**Hunsinger Subdivision**  
**Letter of Intent (Rezoning)**

**August 2018**

**PROPOSAL:** The application covered by this Letter of Intent include a zone change for 8.3 acres from the RR-5 Zone to the RR-2.5 Zone.

RE-ZONE EXHIBIT

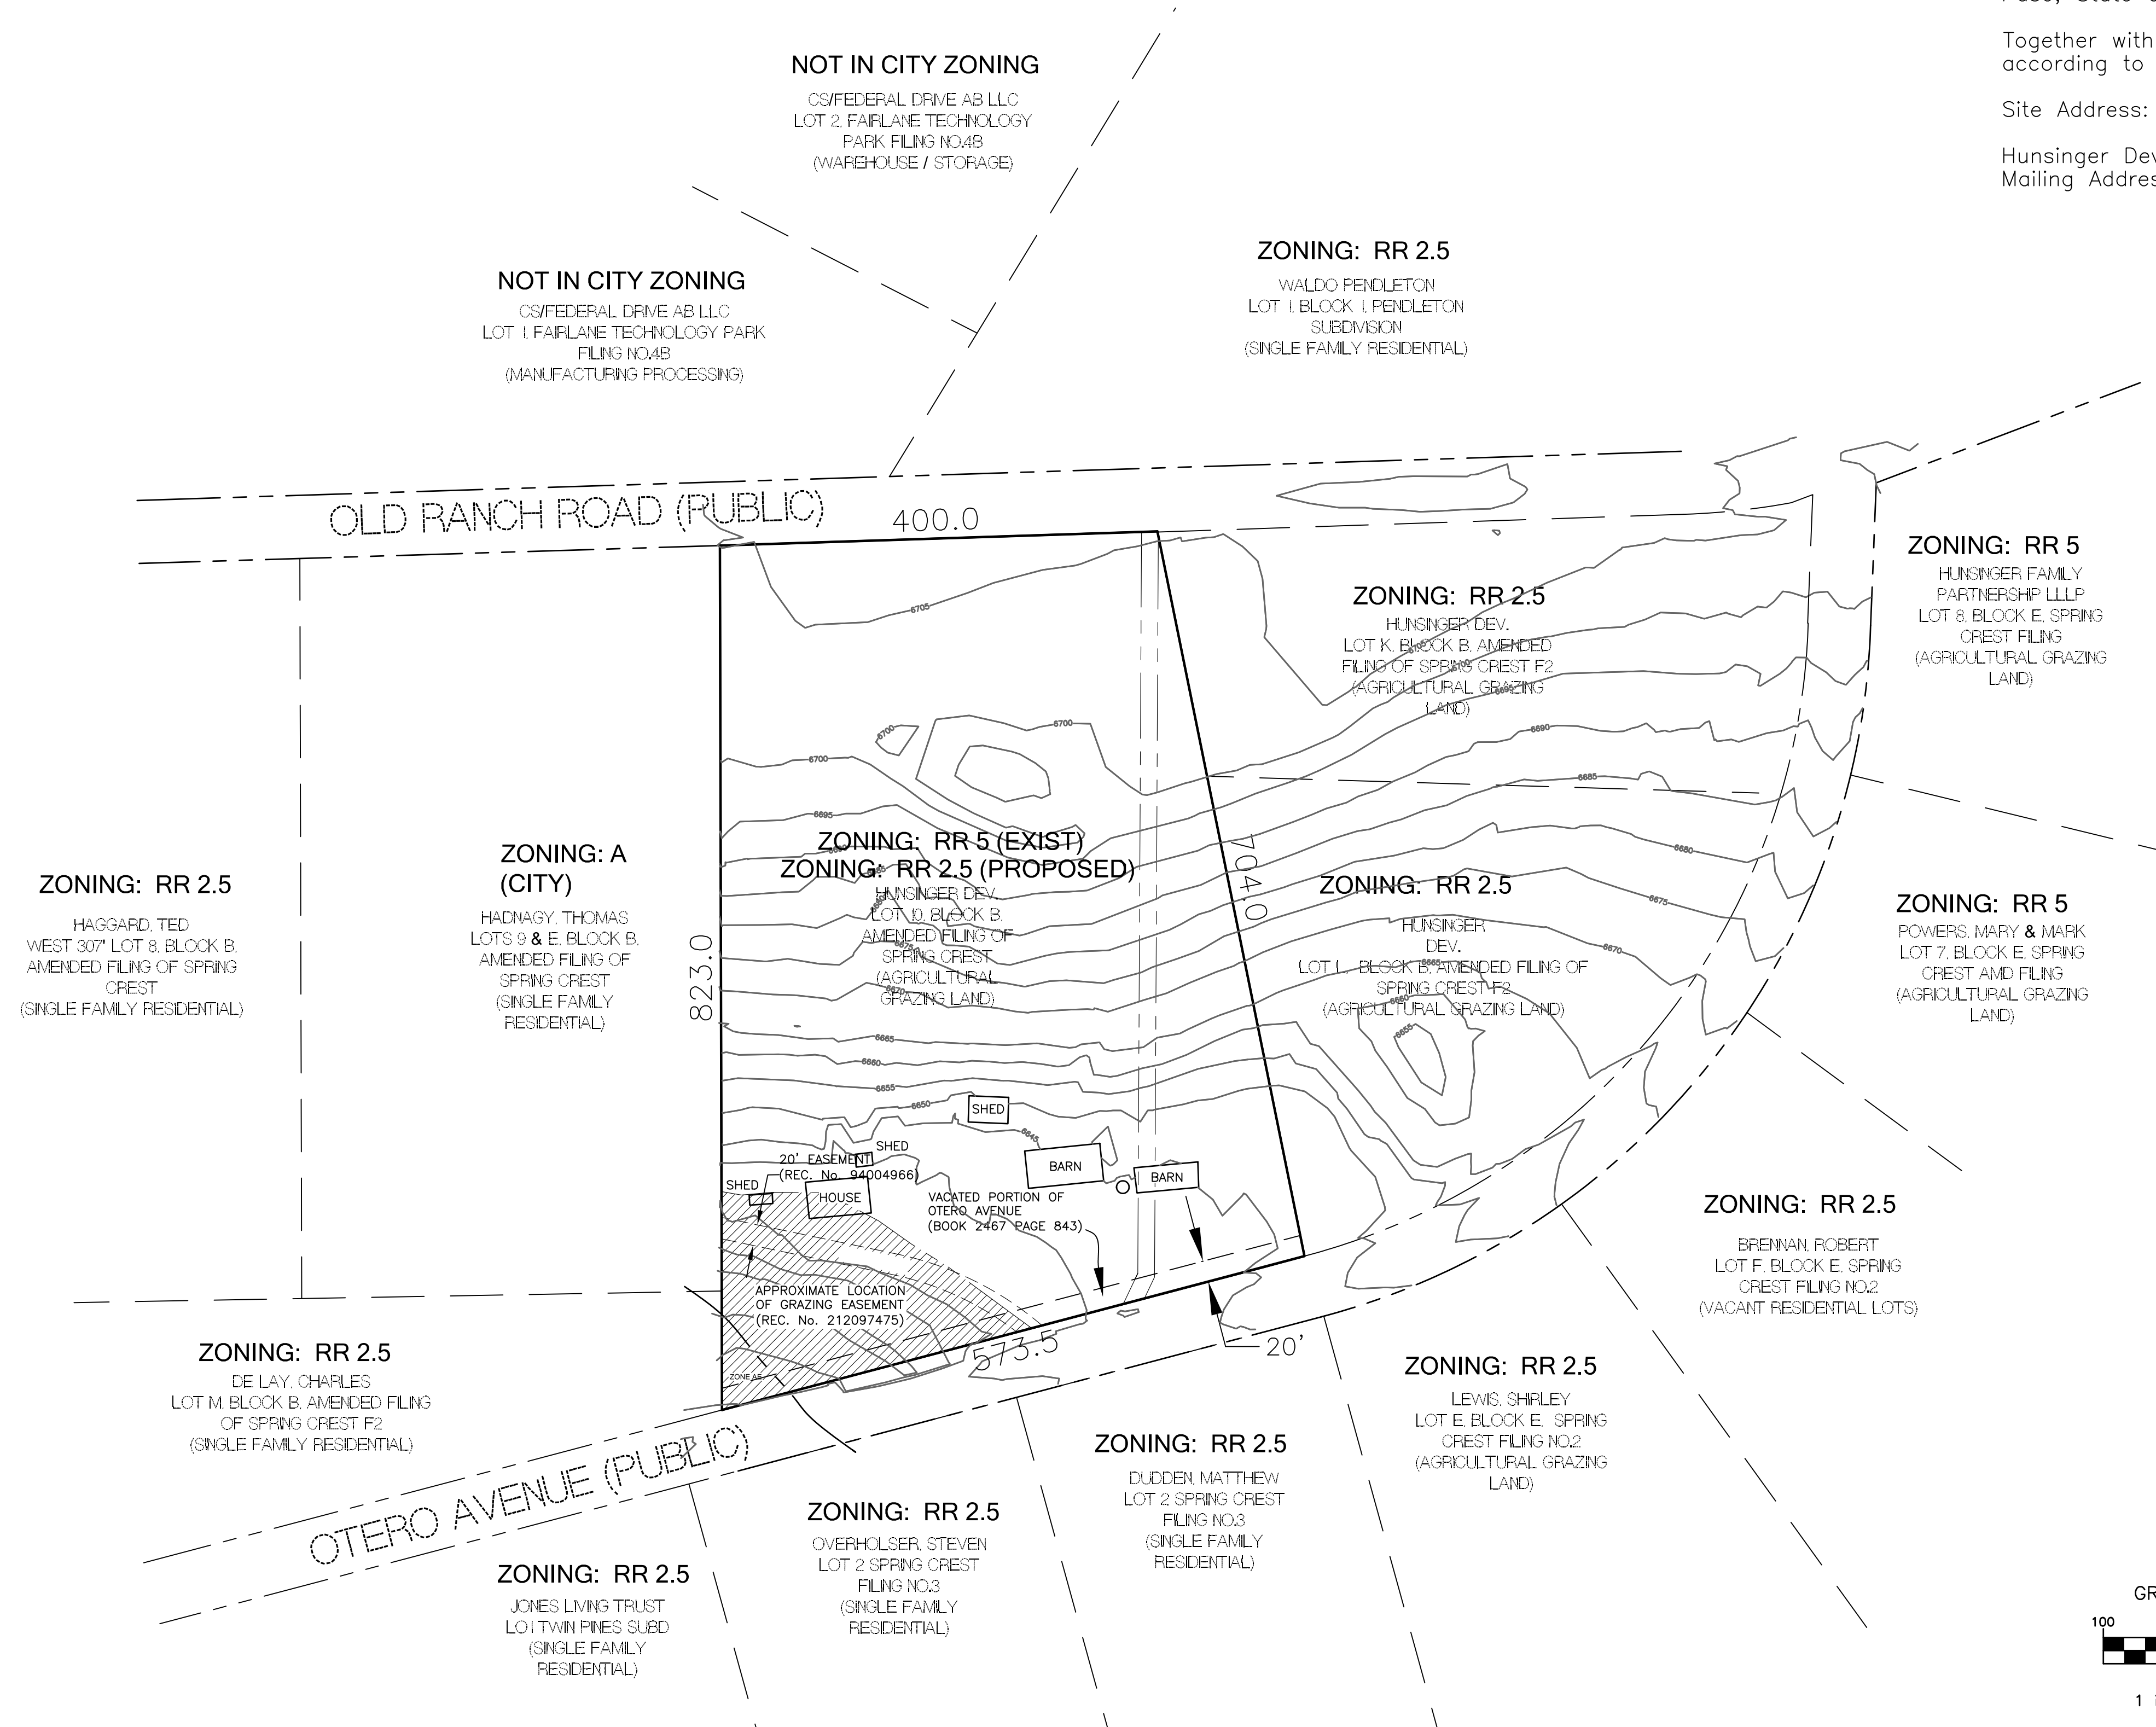
The request must show that the current structure meets the setback requirements for future zoning and that a non-conformity will not be created. Table 5-4 of the LDC has the set backs
